From: Jamie Brown [REDACTED]
Sent: 27 May 2015 09:39
To: Simon Davis
Subject: RE: BE/60/15/PL - Demolition of existing dwelling & erection of 8 No. three bedroom dwellings with new access & car parking

From: Philip Dudley [REDACTED]
Sent: 20 May 2015 22:08
To: Simon Davis
Subject: BE/60/15/PL - Demolition of existing dwelling & erection of 8 No. three bedroom dwellings with new access & car parking

I have amended the drawings to split plots 5 and 6 to detached units. I attach revised drawings for inclusion as amendments to the application.

PROPOSED SITE PLAN
(1:200)

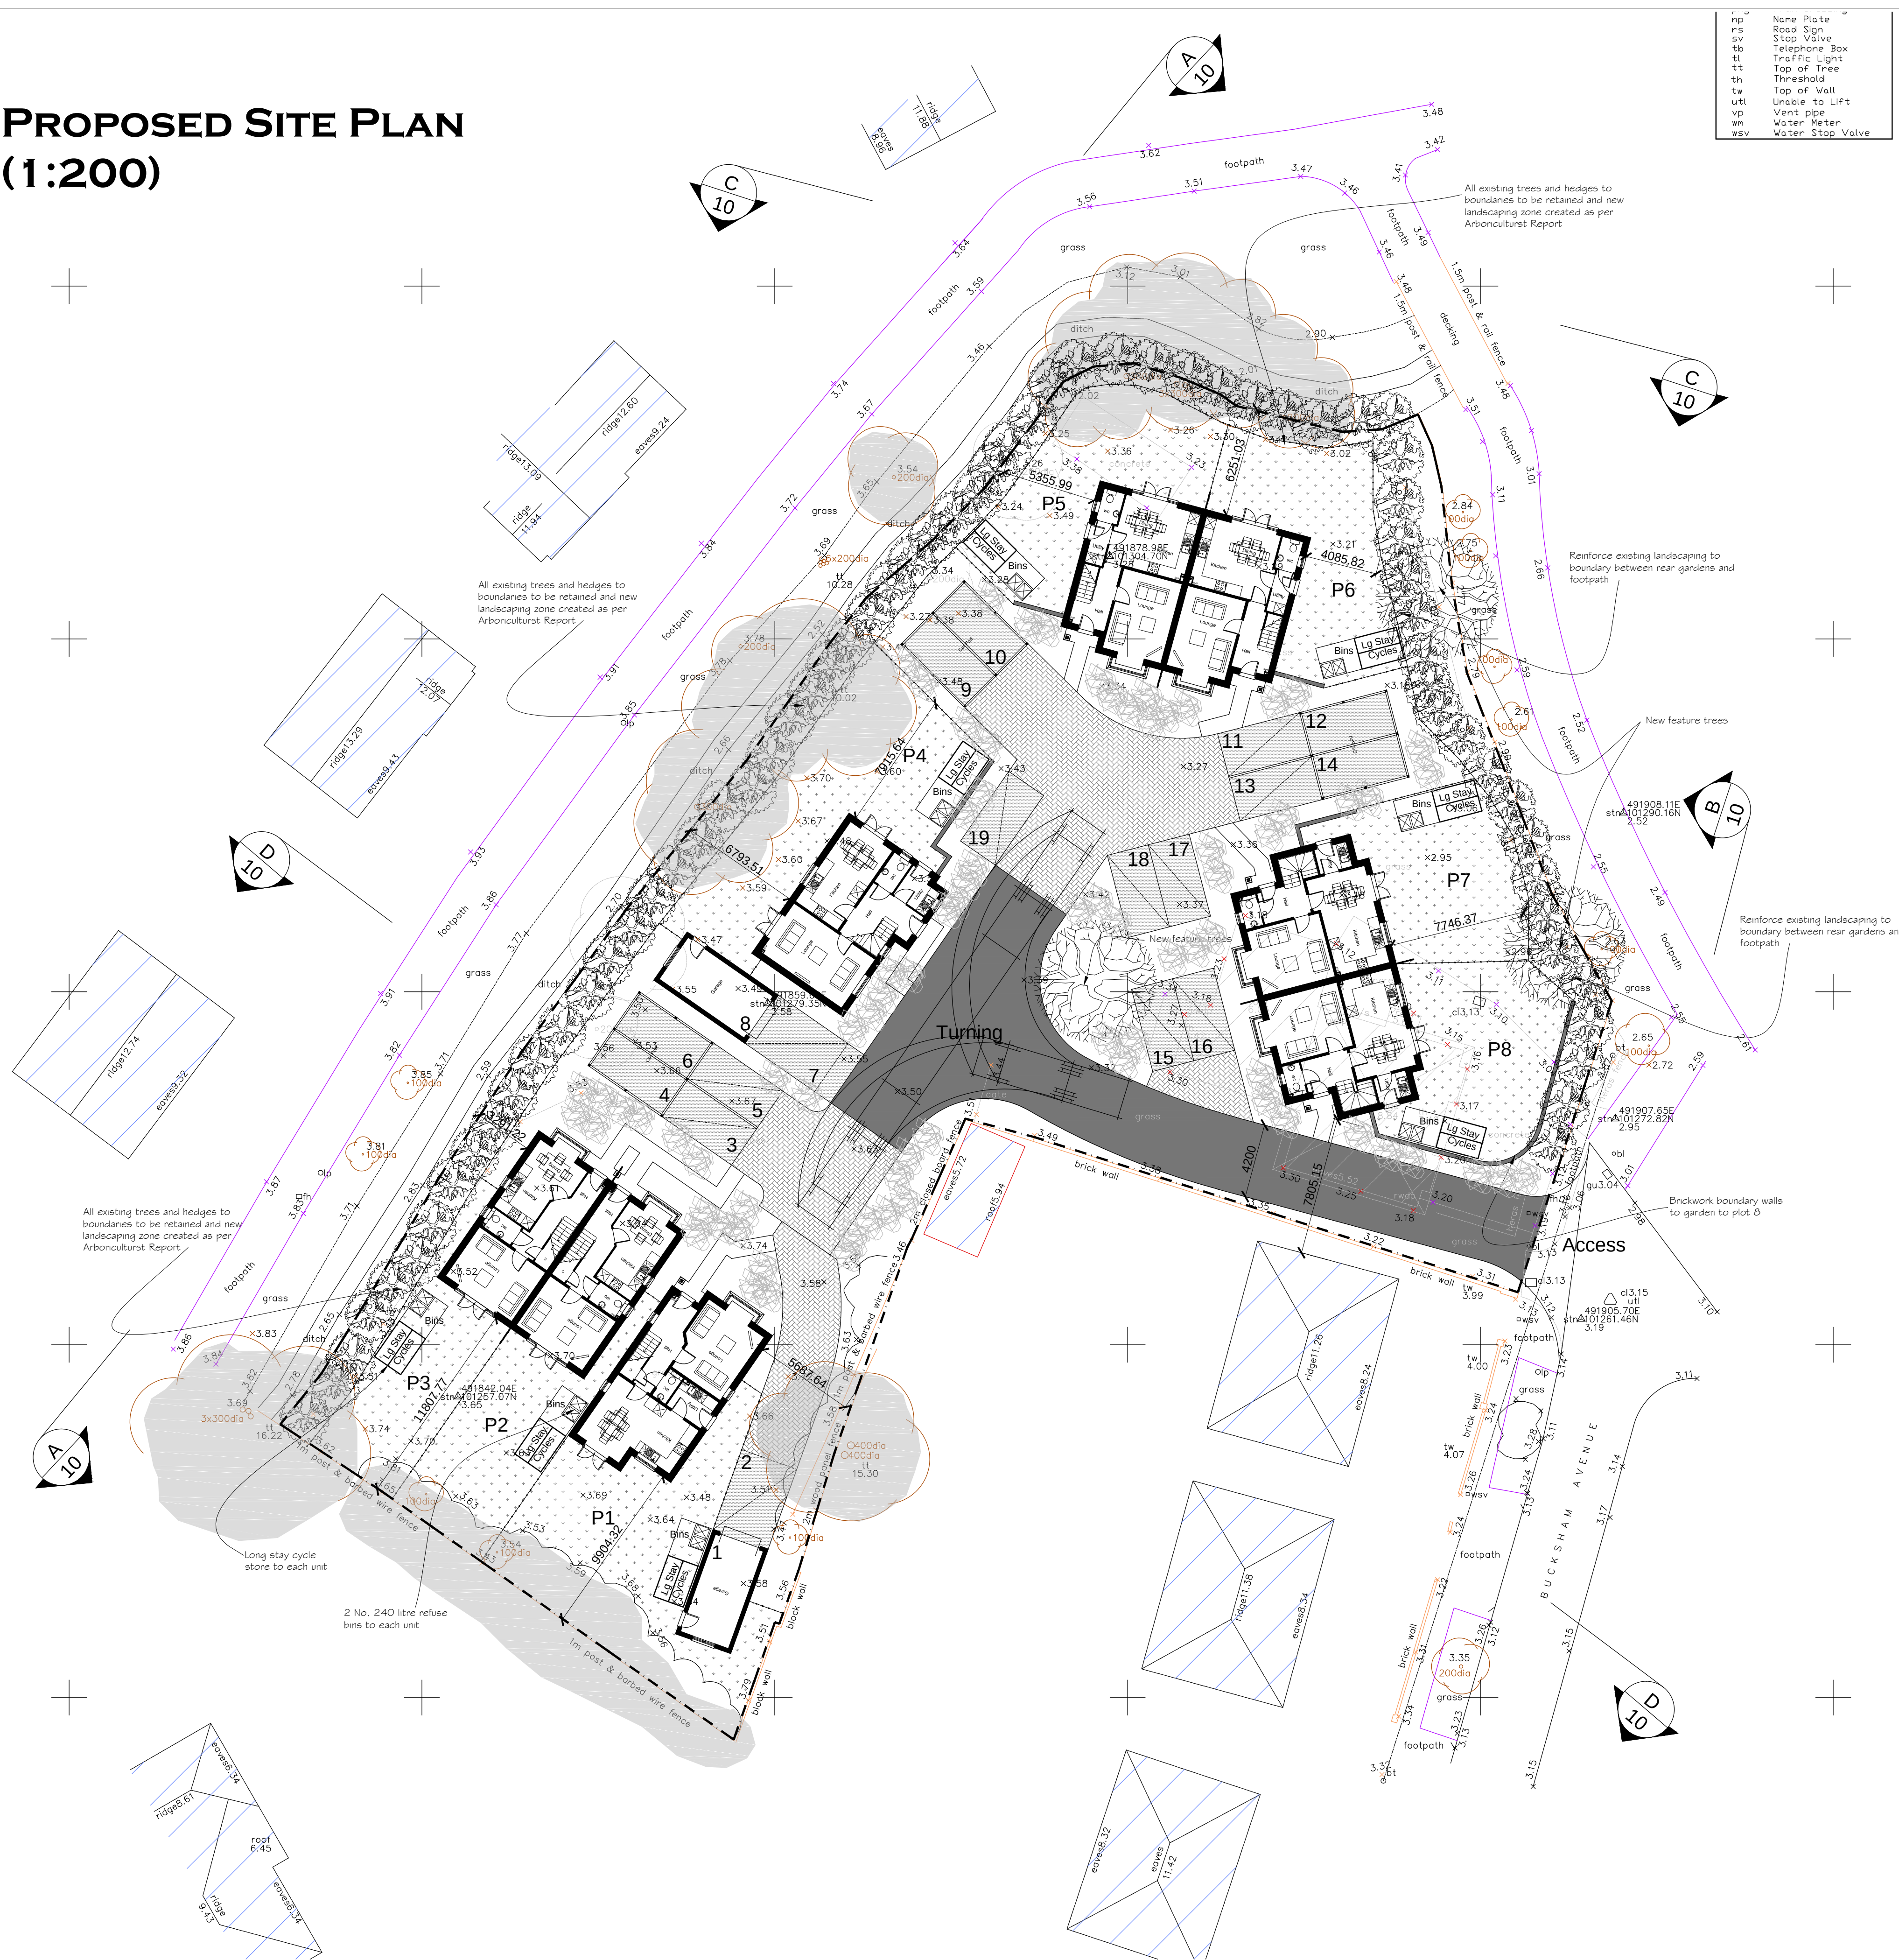
Yes this appears to be acceptable in terms of manoeuvring. This can be covered via a condition I would suggest.

I've received the below email/attached win response to your consultation comments dated 13/05/15. Can you respond re the tracking question/confirm whether the plan meets your concern?

I have also read the comments from highways. A fire engine and refuse truck will need to enter the site and I have shown the turning of the vehicle on the site plan. Can you let me know if they actually want a full tracking plan showing the truck from Bucksham Avenue into the site and out as I will have to get my highways guy to do this with specialist software
